Afra Construction, on behalf of West Mesa RV Park formerly known as Paradise RV Park, request Final Sign Off for Site Development Plan approved by EPC

REFERENCE: WEST MESA PARK – FORMERLY KNOW AS PARADISE RV PARK

PROJECT NO: 1008330 / EPC -40073 PHASE II. AND PROJECT NUMBER PR-2024-010907- DFT APPLICATION NUMBER SI-2024-01331.

L1

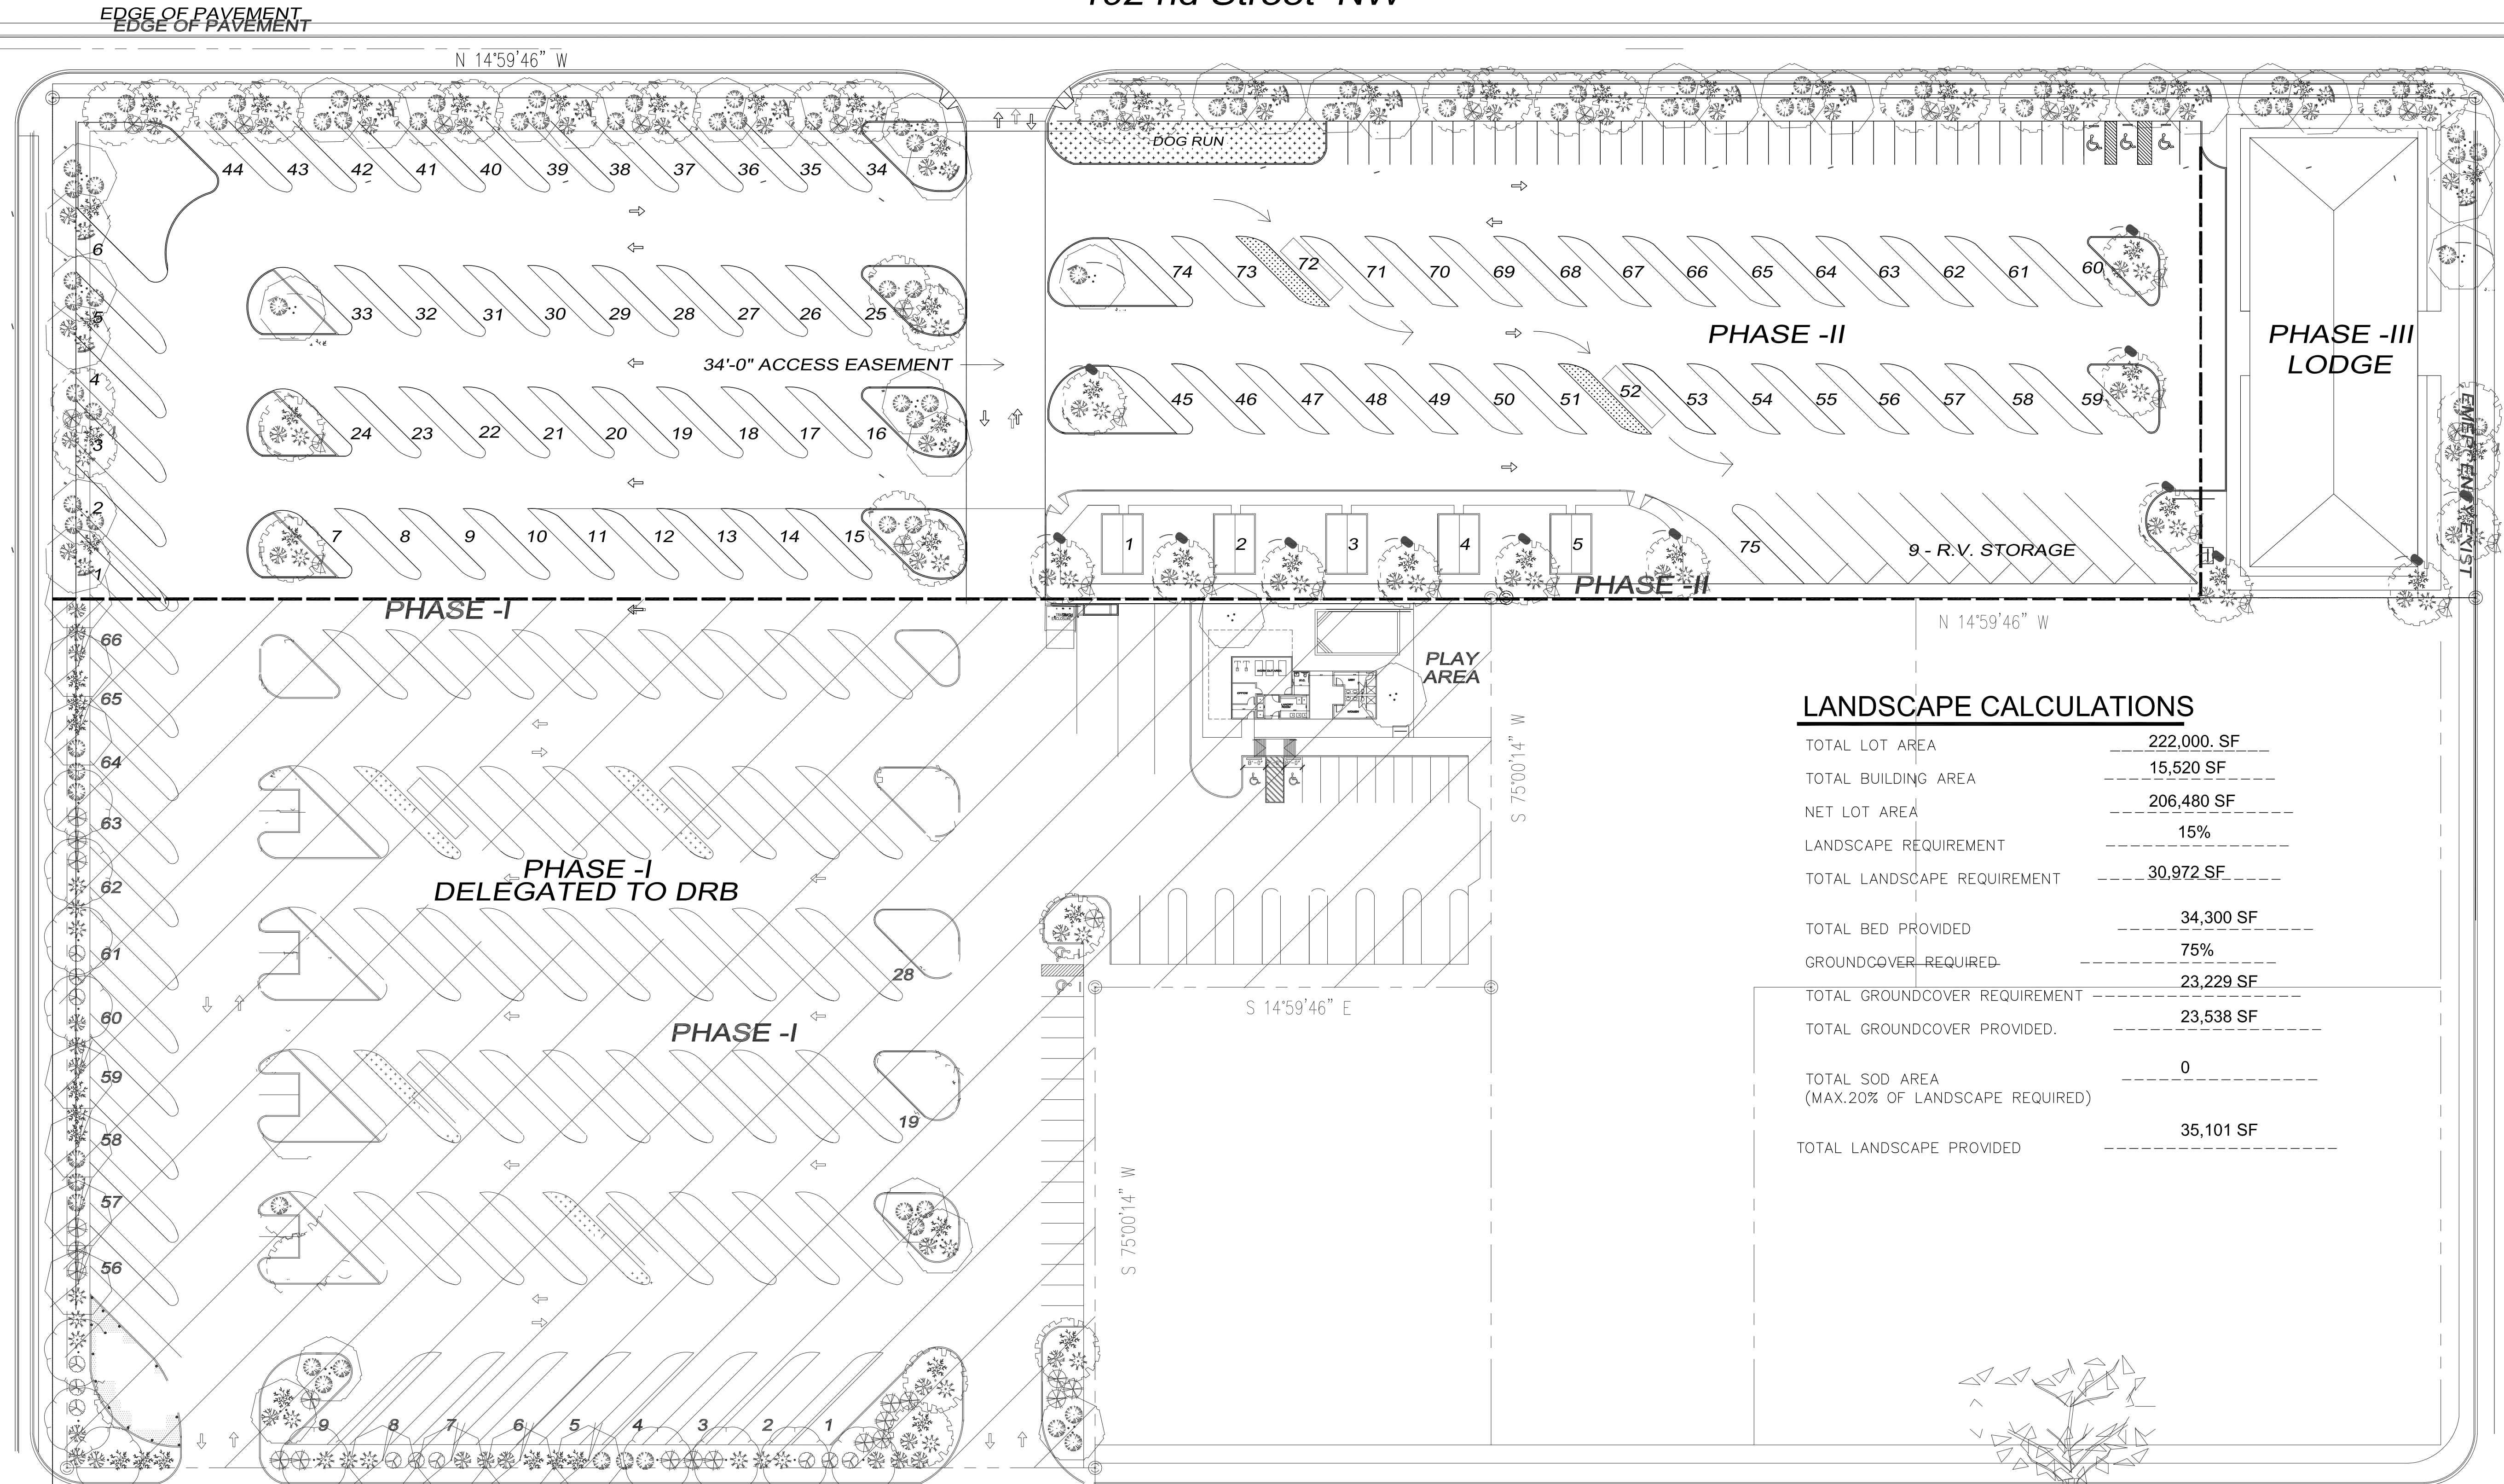
5. Dimensions of the landscape beds and the quantity of each type of planting shall be provided on the Landscape Plan.

**A Landscape Calculation Table is added on Sheet L1. Also, please note that the DFT staff has requested that all the plan sheets be signed and stamped including the Landscape Plans. Since the original Landscape Plans was developed by Hilltop Landscaping which is no longer in service, the applicant had to hire the services of Mitchell Associates, Inc to revise the Landscape Plans and also provide stamped drawings. The three sheets LS-101, LS-102 and LS-103 are hereby attached with the Submittal Package. It is now up to the discretion of the Planner to replace the original Landscape Plans with the Three attached “stamped” sheets.**

A-01

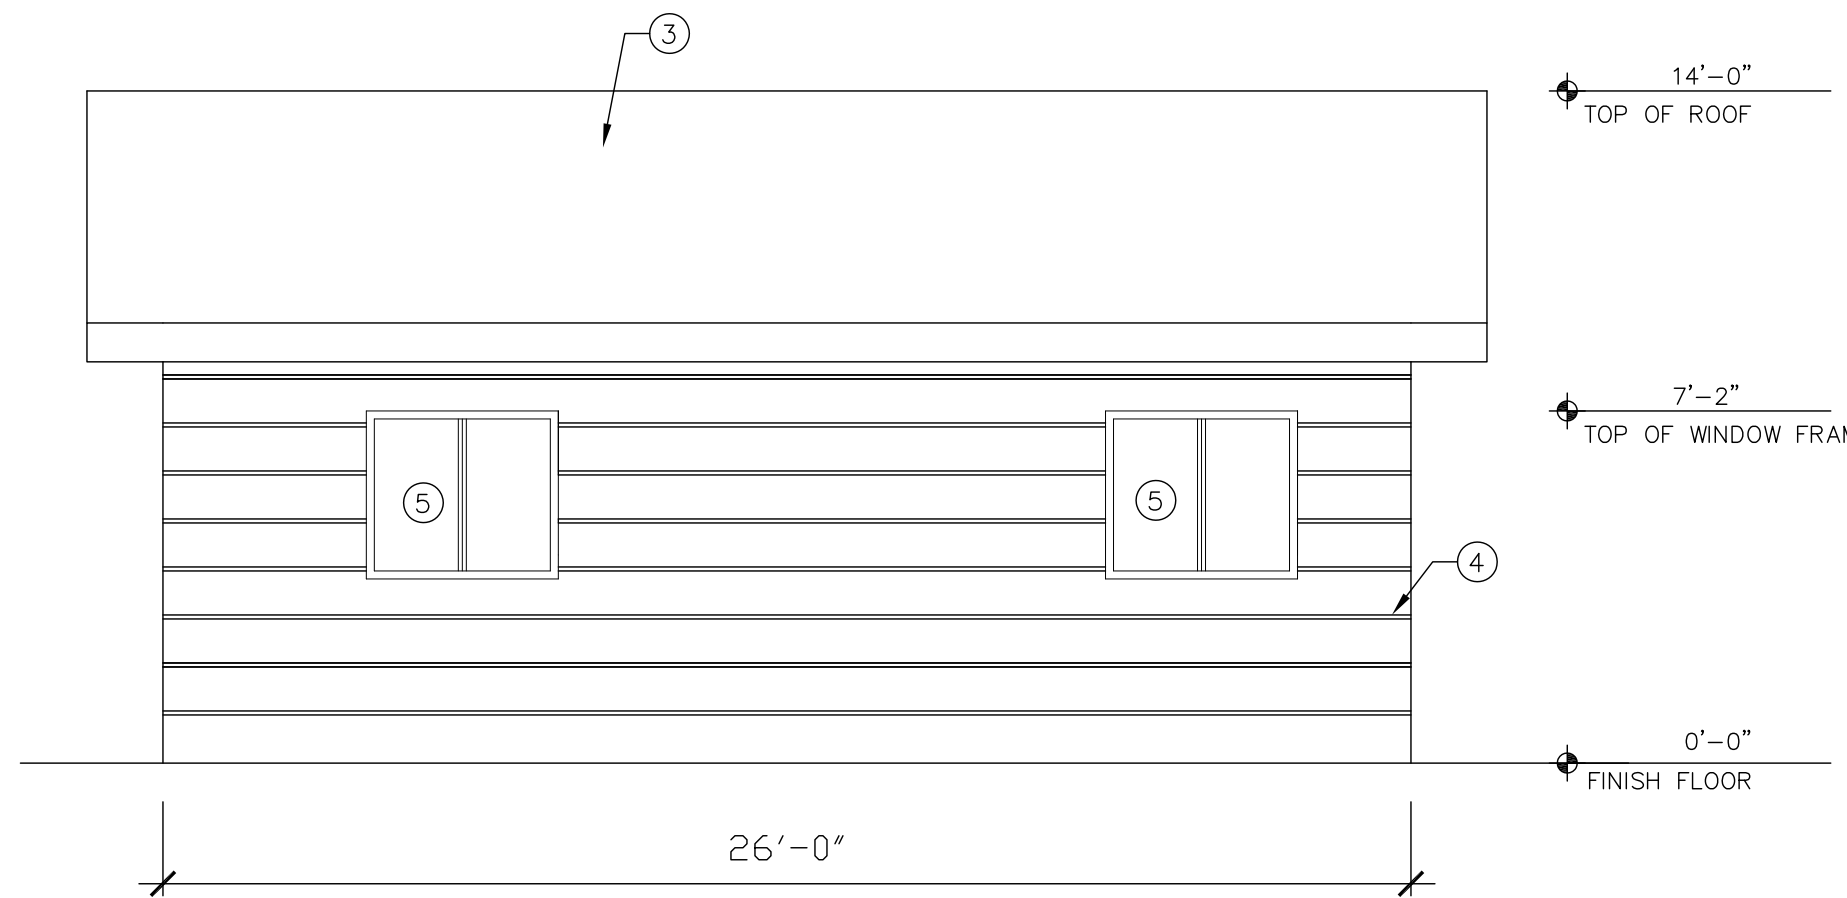
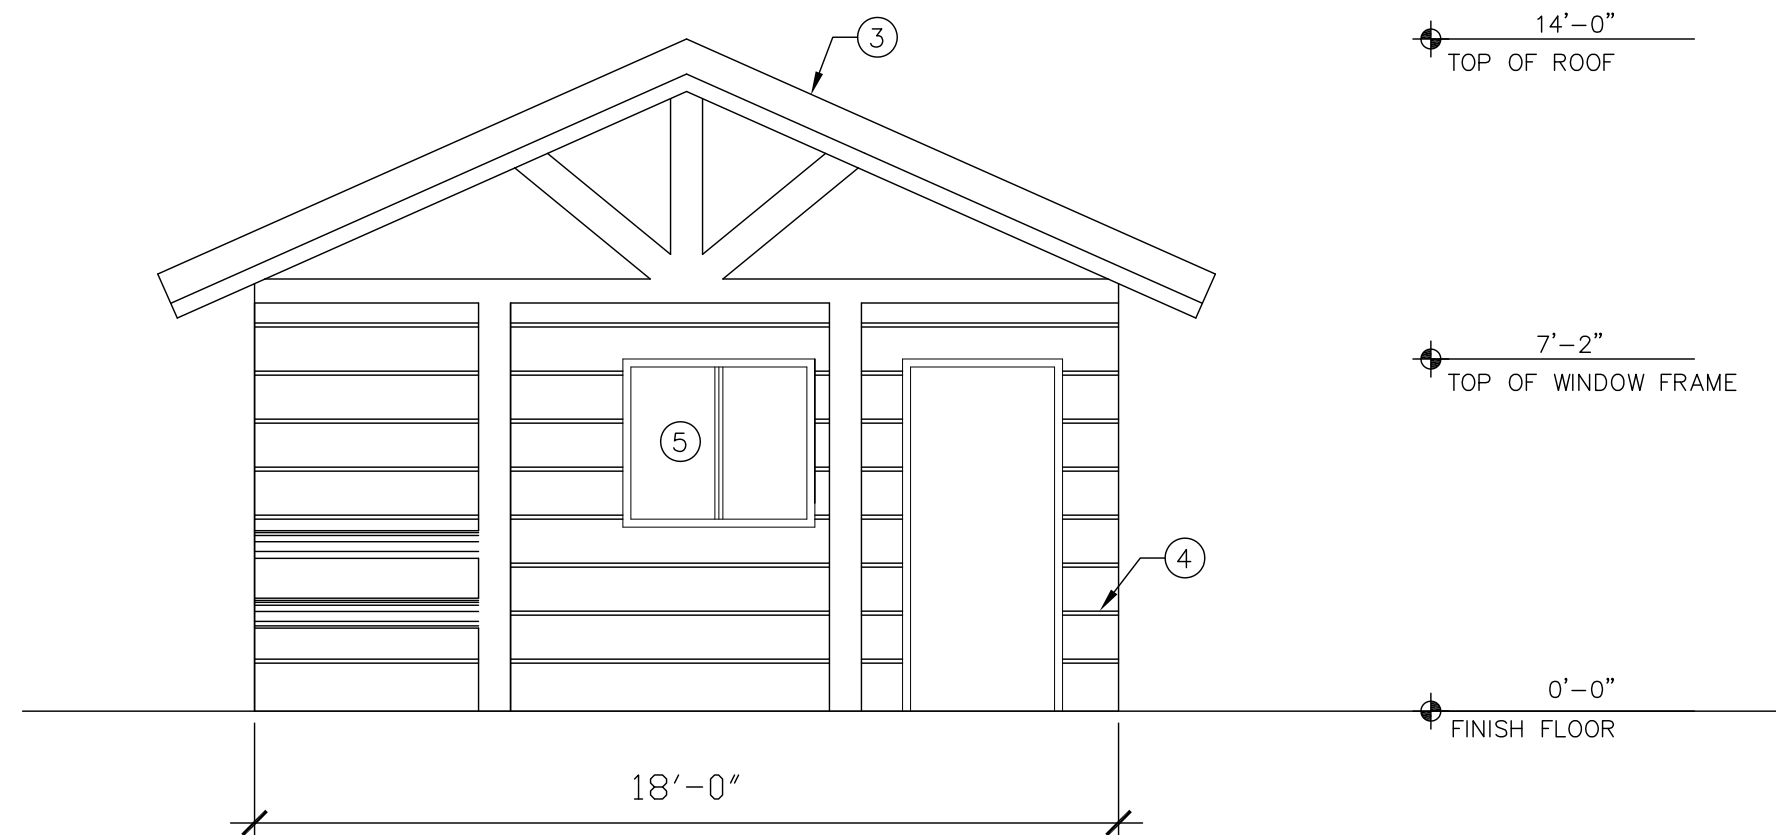
6. Building elevations for all four sides, with dimensions, shall be provided on the Elevation sheets. Details for the windows and doors, including dimensions, shall be provided on the detail sheet.

**All dimensions are shown on Sheets AO-1 and AO-2.**
